# Rezoning Transportation Analysis

Petition Number: 2023-033

**From: Jake Carpenter, PE**  
Jacob.carpenter@charlottenc.gov  
980-221-5675

Date	Description
7-26-23	First Review (IW)
08-24-23	Second Review (NK)
9-20-23	Third Review (NK)
10-25-23	Fourth Review (NK)
11-27-23	Fifth Review (NK)
4-23-24	Sixth Review (NK)

SHEET NUMBER  
**RZ2-00**

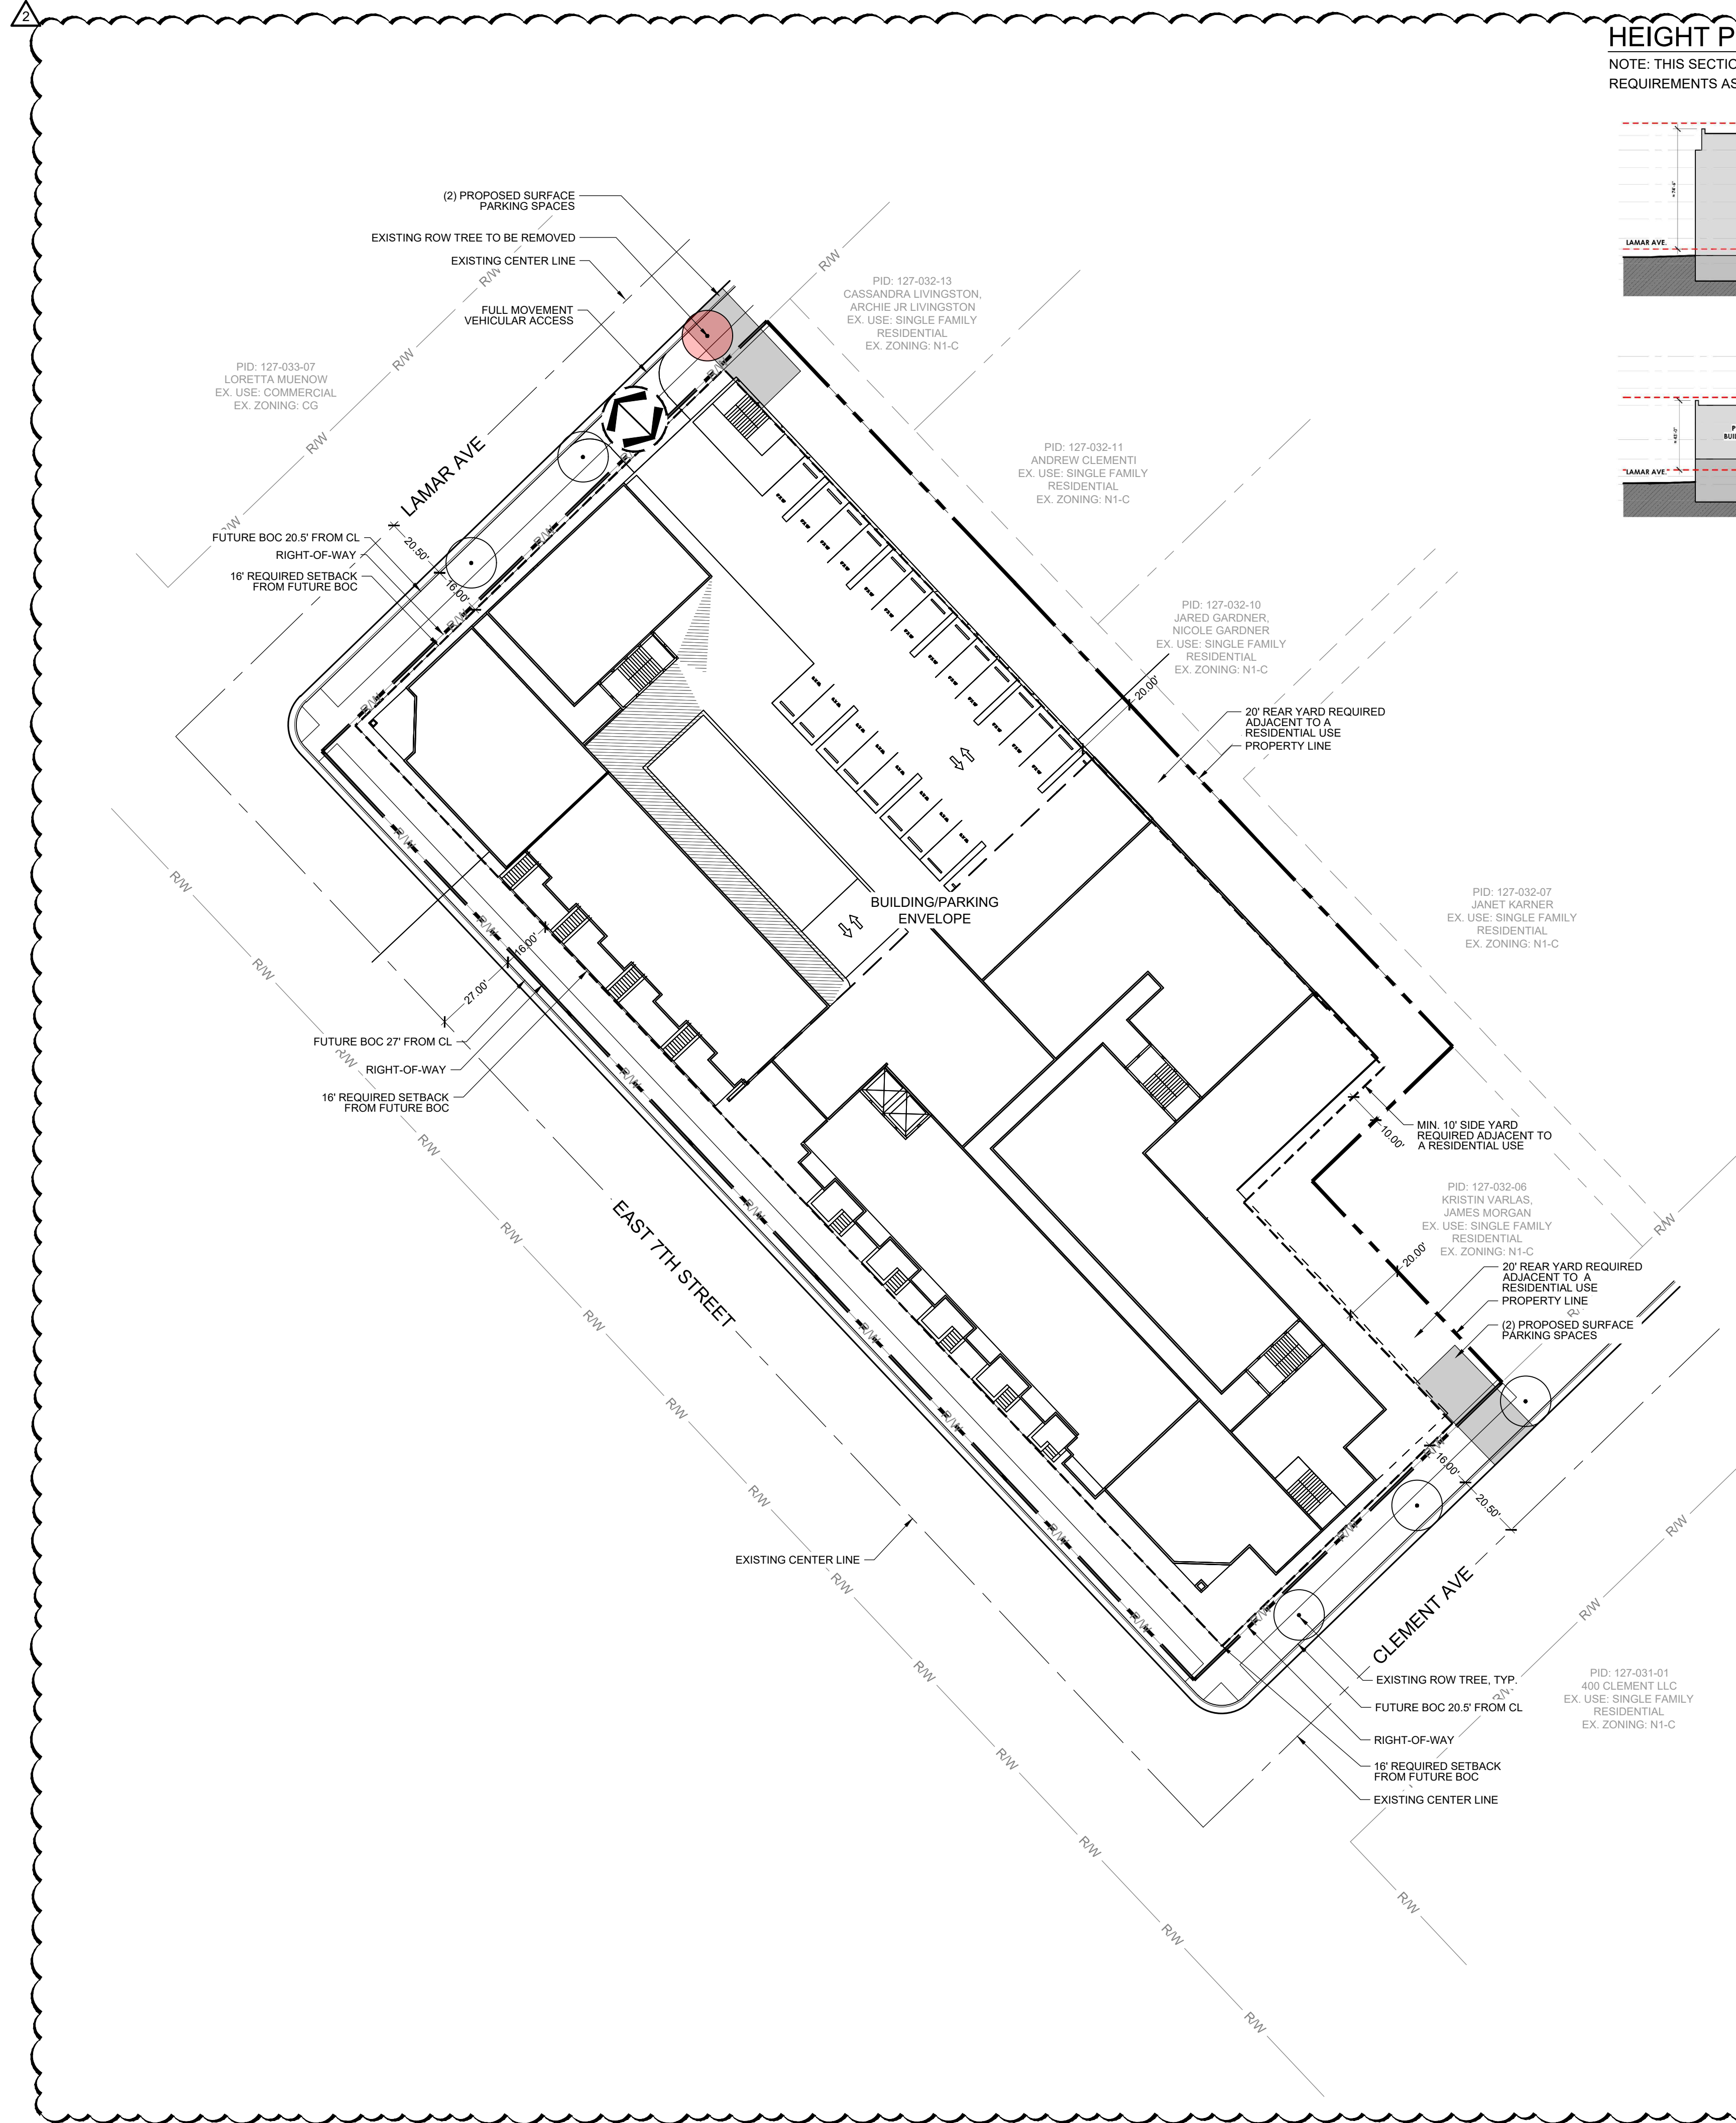
Label and dimension the curb and gutter from the centerline for each road on the site plan.

**Clarifying Comment 8-24-23:** Revise site plan to reflect proposed 45 feet of right of way dedication. Site plan shall label and dimension from roadway centerline.

**Clarifying Comment 8-24-23:** Label and dimension sidewalk and planting strip on the site plan.

**Clarifying Comment 8-24-23:** It is unclear whether proposed parking spaces are encroaching on the required streetscape on Clement and Lamar Ave., provide additional clarification.

**Clarifying Comment 8-24-23:** Sidewalk must be located within ROW or a sidewalk utility easement, which must extend an additional 2-feet behind sidewalk. Site plan shall label and dimension ROW/SUE. If a sidewalk utility easement is utilized, include a conditional note regarding commitment to placing sidewalk within easement.

**LEVEL 1 SCHEMATIC PLAN**

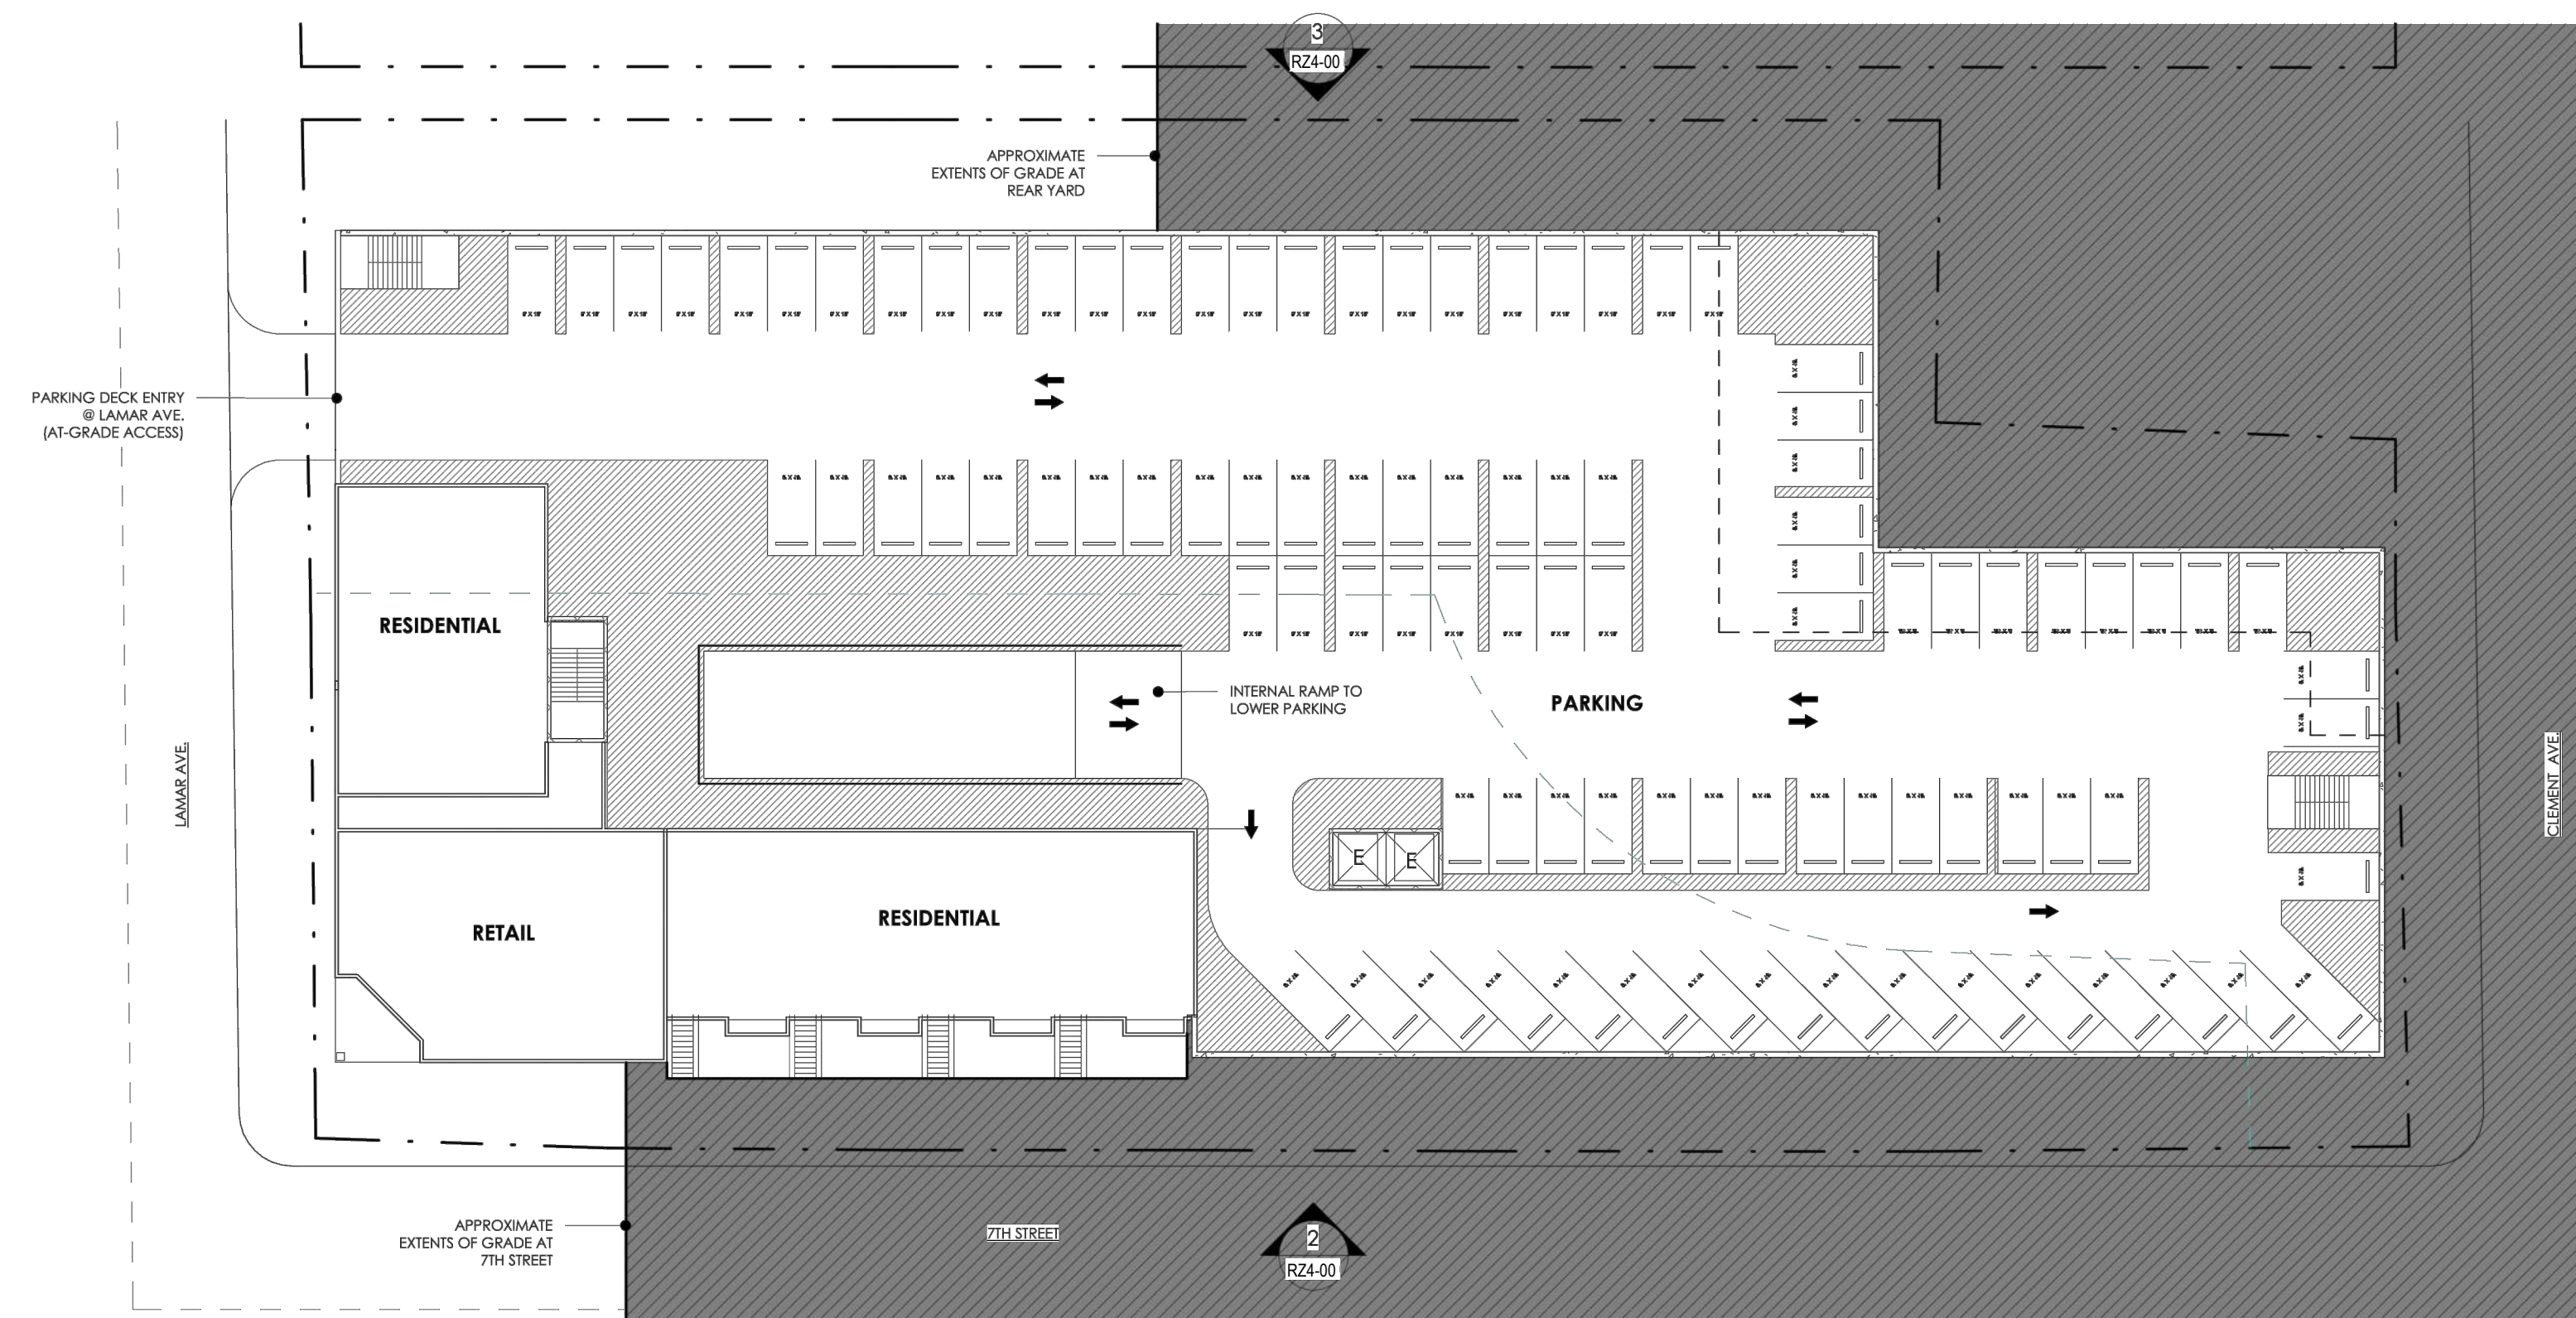
**Clarifying Comment 9-20-23:** Remove the additional parking spaces on Clement and Lamar Ave. Access to parking spaces is not allowed over a streetscape. This access would be considered a driveway and would be required to meet minimum driveway standards including geometric design, spacing, and internal stem requirements.
